DECISION DELEGATED TO HEAD OF PLANNING

Application No: H09-0606-23 **Applicant:** Ashwood Homes Ltd

Proposal: Details of proposed boundary treatments & details of existing & proposed site levels & floor levels (Conditions 4 & 8 of H09-0276-19)

Location: Partridge Road, Off Fen Road Holbeach Spalding

DRAWING TITLE:
SITE SECTIONS - NORTHERN BOUNDARY

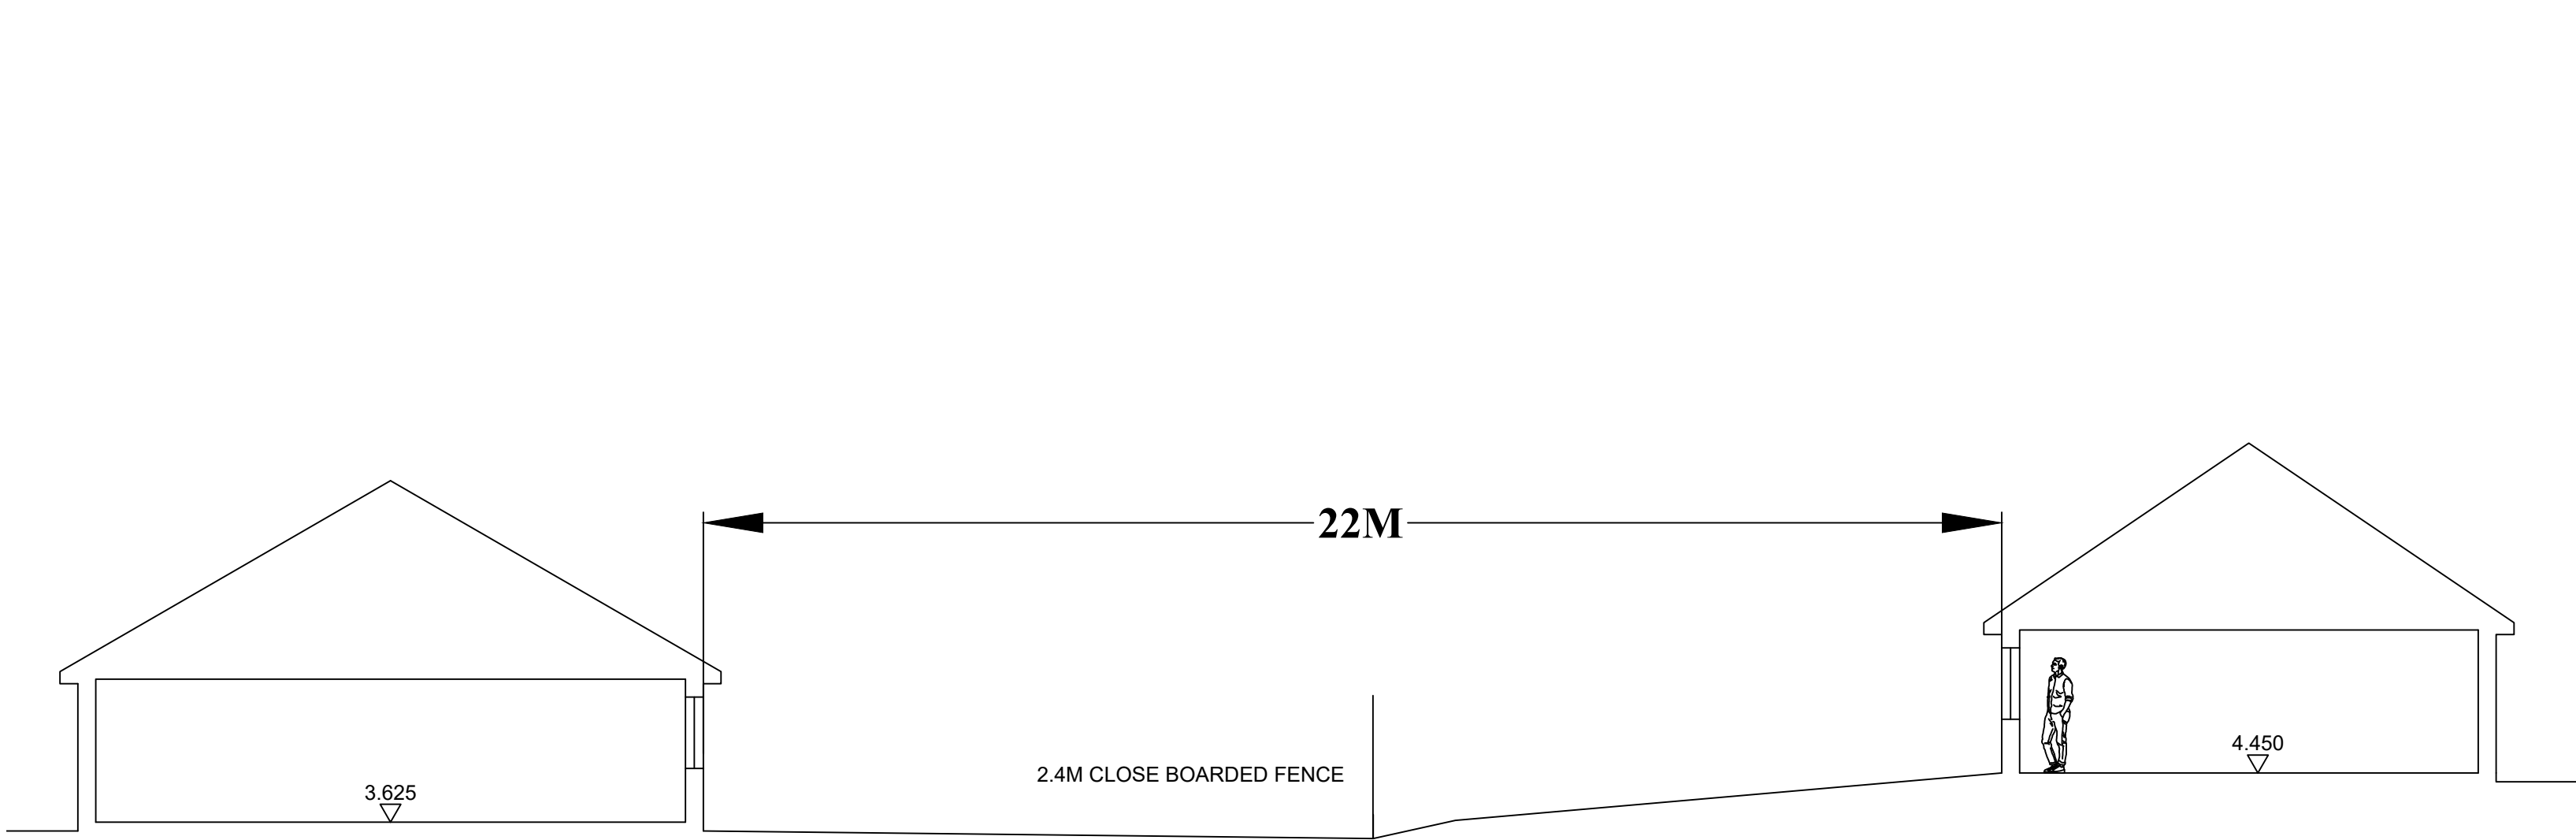
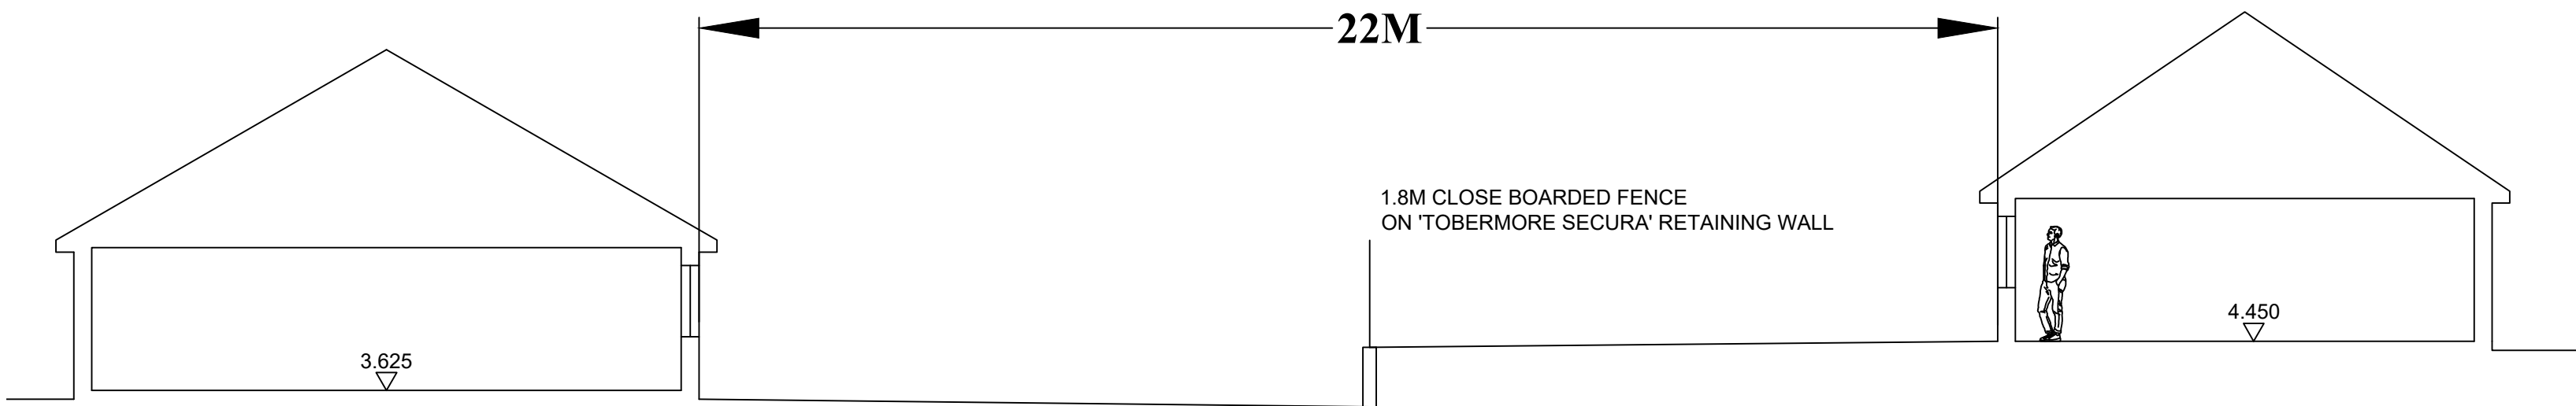
The boundary treatments hereby submitted largely reflect those previously approved with the exception of the northern boundary, whereby the previously approved 2.4m high close boarded fence has been replaced with the proposed retaining wall with 1.8m high fencing above.

These boundary treatments, including the retaining wall with 1.8m high fencing are considered to be acceptable.

The details in respect of levels, which largely reflect those previously proposed albeit comprise some alterations, are to be read in conjunction with the details submitted for conditions 4, and are considered to be acceptable.
